Phone: 0300 123 6780
Email: Kathryn.Walsh@lancashire.gov.uk
Your ref: 3/2024/1019
Our ref: 3/2024/1019/HDC/KW
Date: 30 January 2025

Location: Kemple Down Birdy Brow Chaigley BB7 3LR
Proposal: Proposed demolition of granny annexe and single-storey extension, internal remodelling and extension of the house, construction of new double garage and garden store.
Grid Ref: 369446 440780

Kate Walsh
Assistant Engineer
Highway Development Control
Highways and Transport
Lancashire County Council
T: 01772 533235
W: <http://www.lancashire.gov.uk>

EX.01

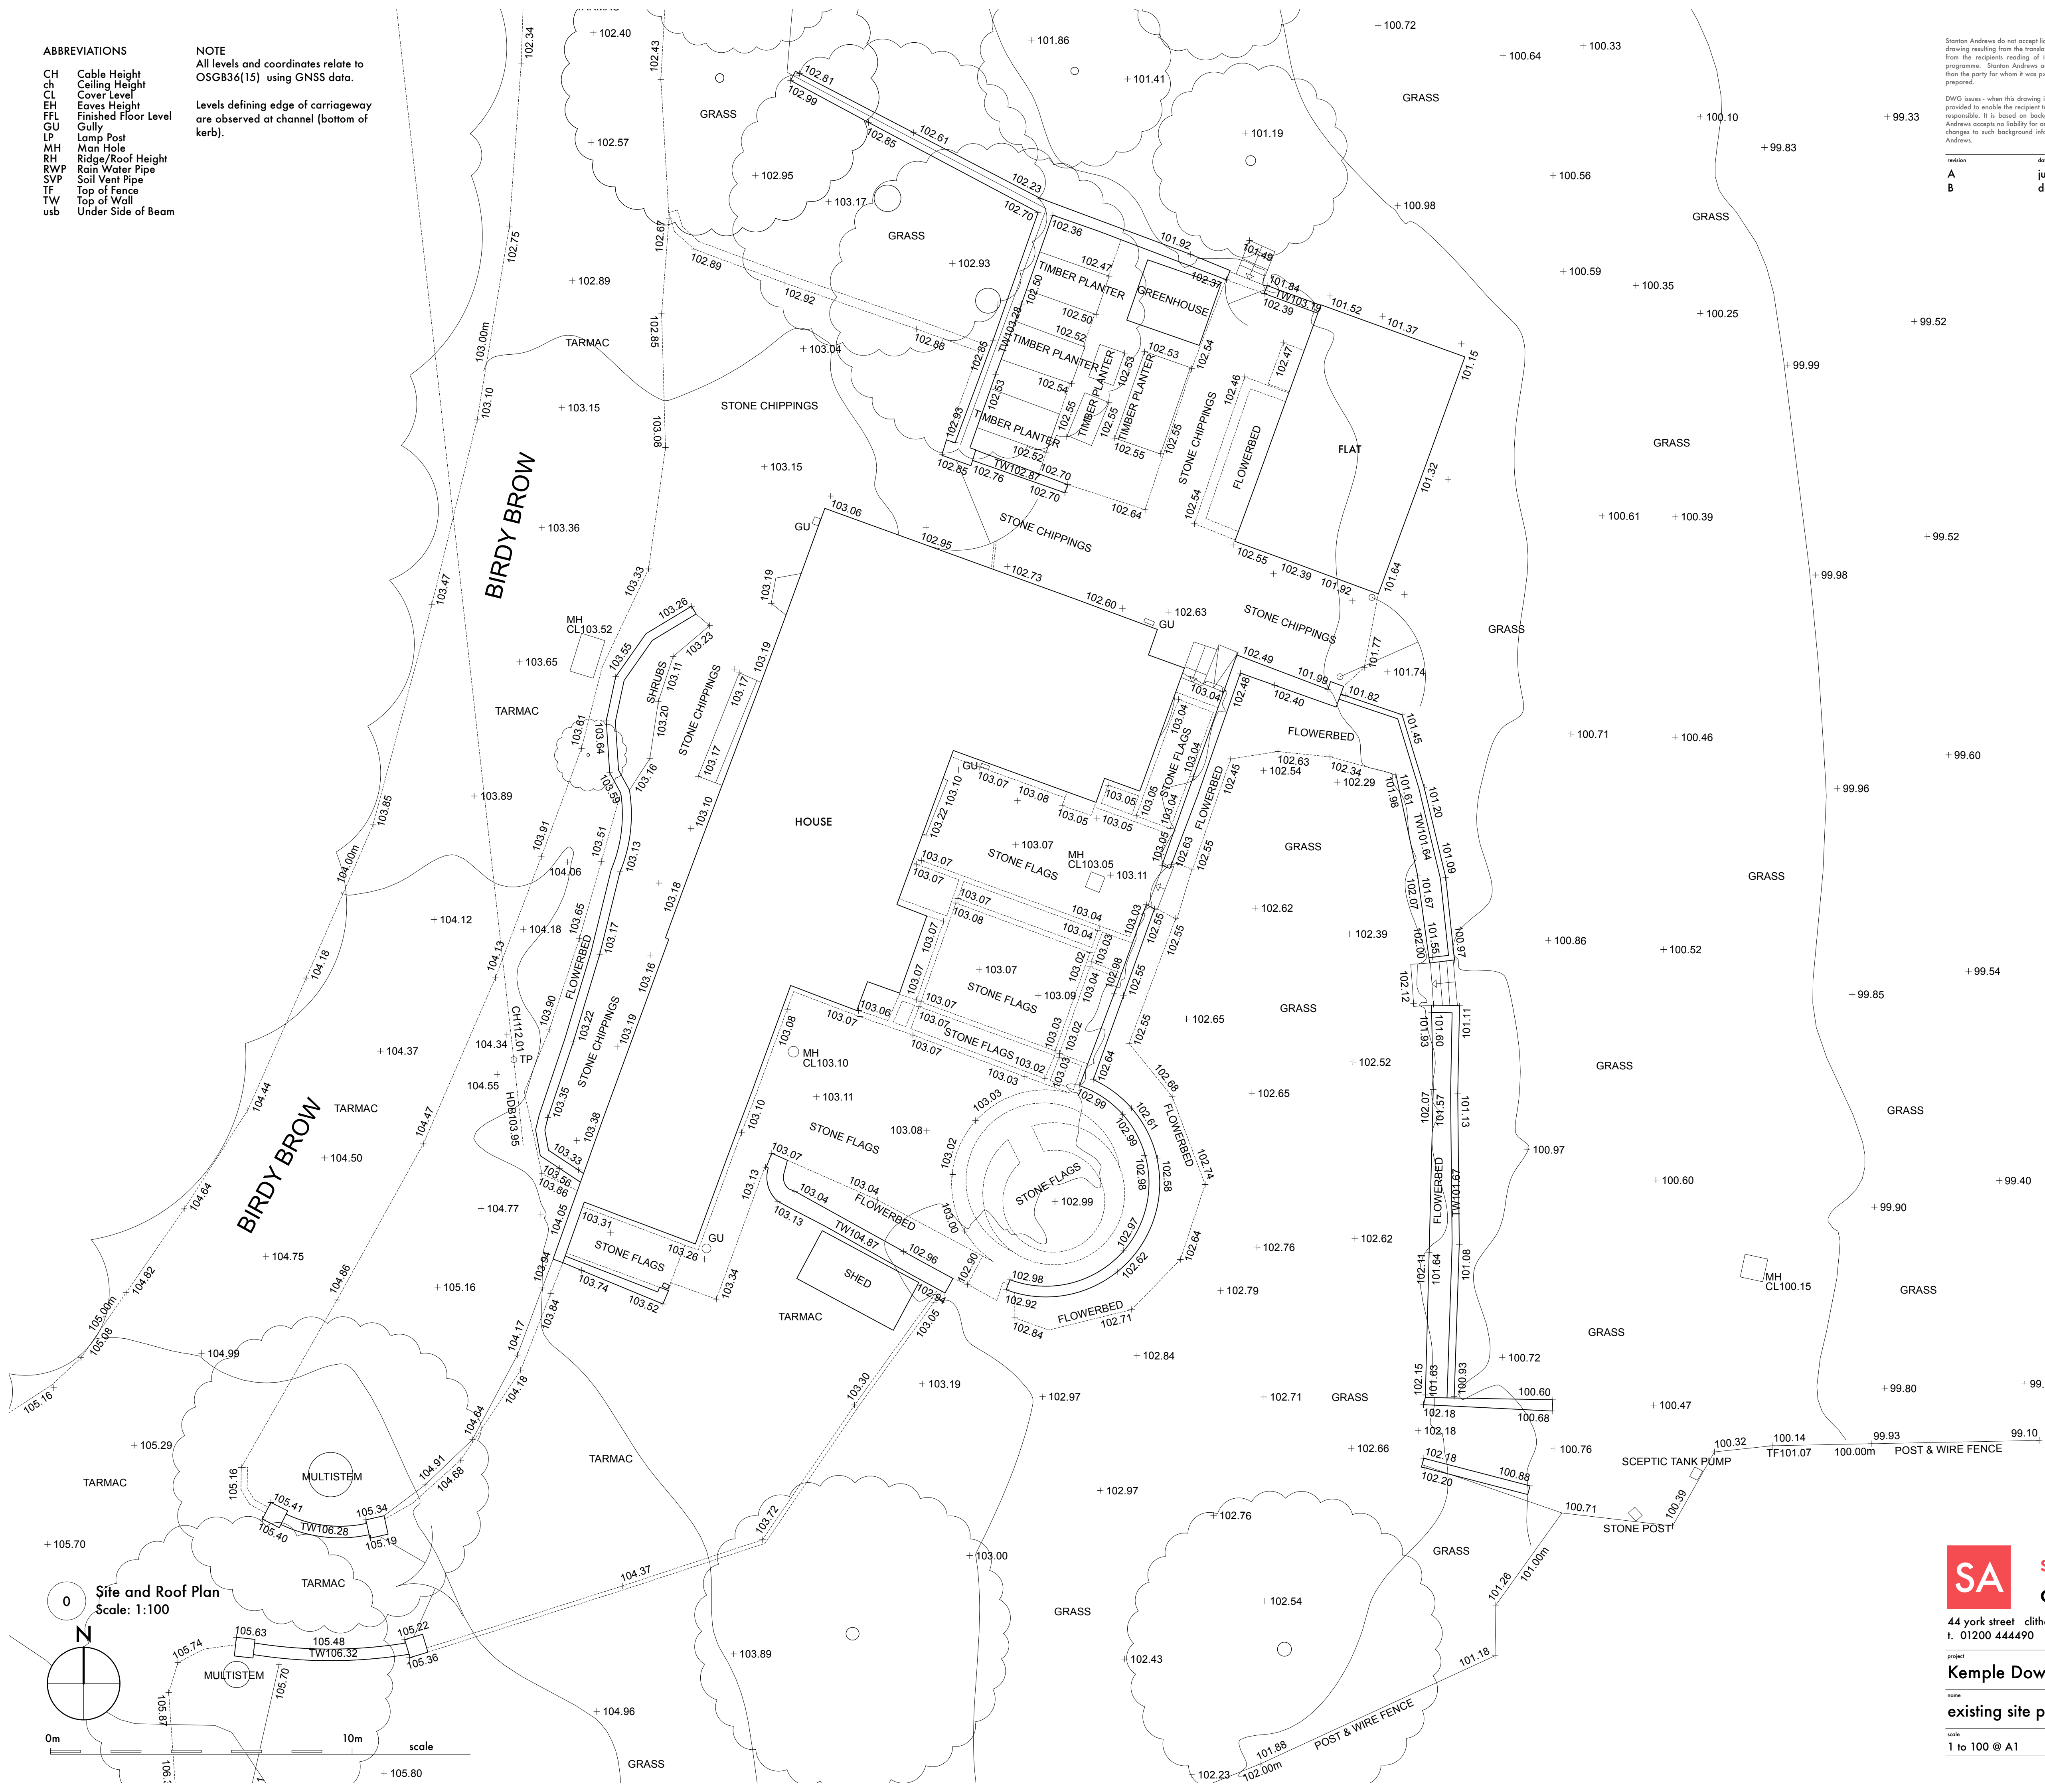
The LHA understands that the site has two existing accesses as shown on drawing EX.01, Rev B. The application includes the removal of the access which sits further south on the highway frontage.

On site observations, found that the access which sits further south has a clearer visibility splay than the access which the applicant would like to retain, therefore there are concerns that the proposal will result in an access which is not acceptable in terms of highway safety.

To ensure adequate intervisibility between highway users at a new access a visibility plays set 2.4 metres back from the near edge of the carriageway and extending 215 metres along the nearside carriageway edge in both directions should be provided, as prescribed in the DMRB.

Whilst the Proposed Site and Roof Plan drawing PL.04 Rev A shows that a visibility splay has been provided, the drawing does not clearly show the entire splay. Therefore, it is expected that the applicant provides a clear visibility splay drawing meeting the requirements above or the maximum splay that can be achieved in both directions at the access.
